From: Sue Howell
Sent: 29 May 2014 17:00
To: Planning.Responses
Cc: Cian Cronin
Subject: RE: Planning Consultation on: F/9/14/PL

Comments from Greenspace

APPLICATION F/9/14/PL

Description of Works: Application for outline planning permission with some matters reserved for 45 No new dwellings and new access. This application also lies within the parish of Yapton.

Proposed residential site plan

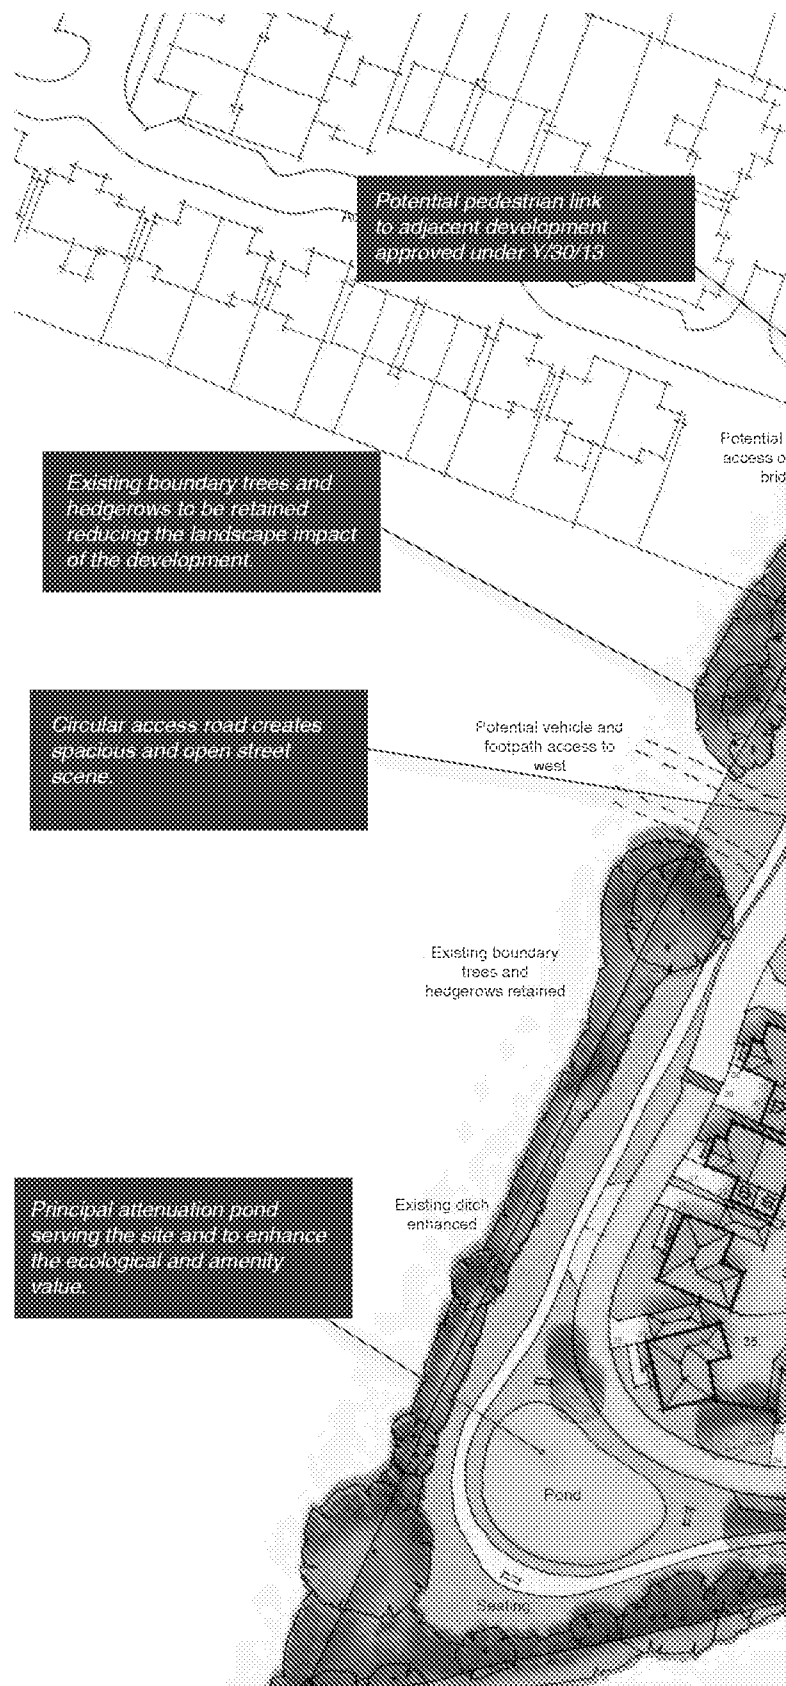
The Council's SPG guidelines apply to developments of houses and are based broadly upon the National Playing Fields Association's (NPFA) "Six Acre Standard". This requires that 2.4 hectares of open space (or six acres) are provided for every 1,000 people ie 24 square metres of open space per person. In this development this would equate to 2592m² which guidelines suggest would require on-site public open space, this we would be requesting as relief development on this site. With the number of houses on this proposal exceeding 15 this would also trigger the need for onsite LAP and landscaped open space. Falling just short of requirement for LEAP and multiple LAPs on site whilst considering the proximity to existing offsite play provision we would be seeking a contribution to improvements to this already existing offsite provision at a rate of £1,000 per property. The areas of onsite open space are primarily to the periphery of the site with a smaller central area, whilst this is beneficial to the tree development in these areas an increased central open space area would be desirable.

Maintenance of the open space areas post construction needs to be detailed along with guidelines of who will take ownership of these and how the open space areas will be maintained. The timescale for how this will be achieved will also need to be agreed. The area indicated as 'pond' on the proposed sketch layout would need to be subject to a ROSPA inspection due to the proximity to public open space and pathway areas.
